CITY OF ALBUQUERQUE

Re: Cielo at Copper Master Grading and Drainage Plan
Engineer's Stamp dated 2-26-07 (K17/D098)

Based upon the information provided in your submittal dated 2-27-07, the above referenced plan cannot be approved for Preliminary Plat action by the DRB until the following comments are addressed:

TITLE: CEILO AT COPPER
MASTER GRADING PLAN

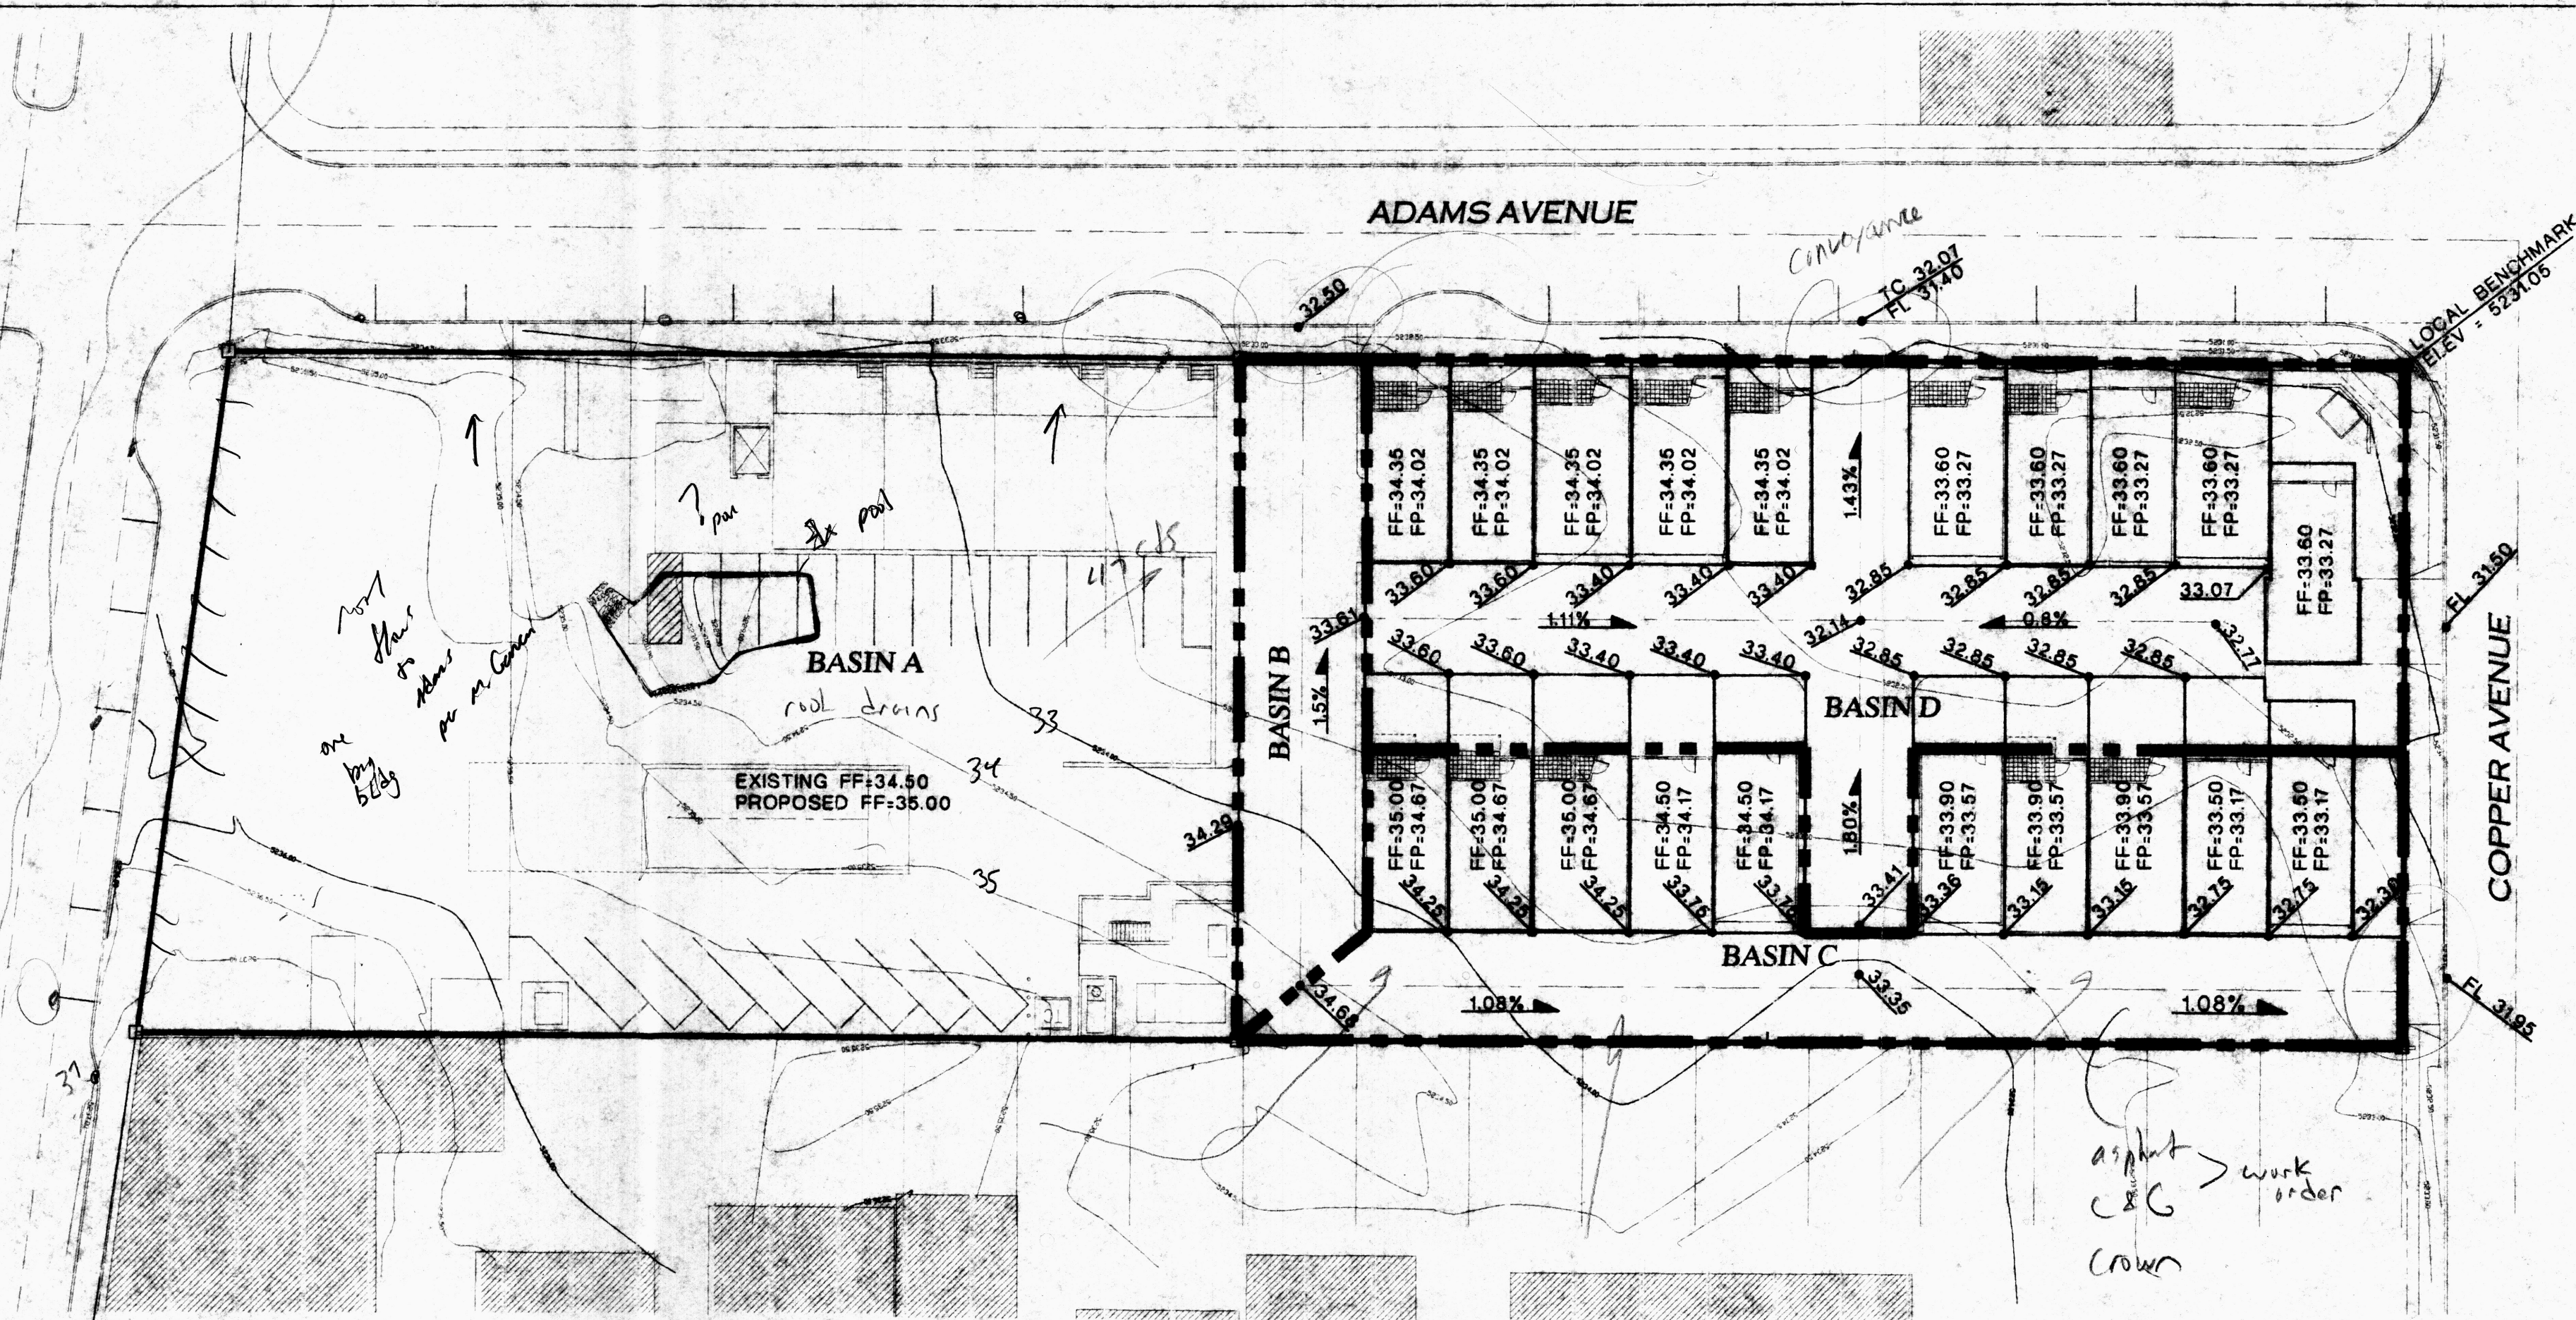
- Provide a discussion of offsite flows.
- What are the floodzone elevations in Central and Copper Avenues?
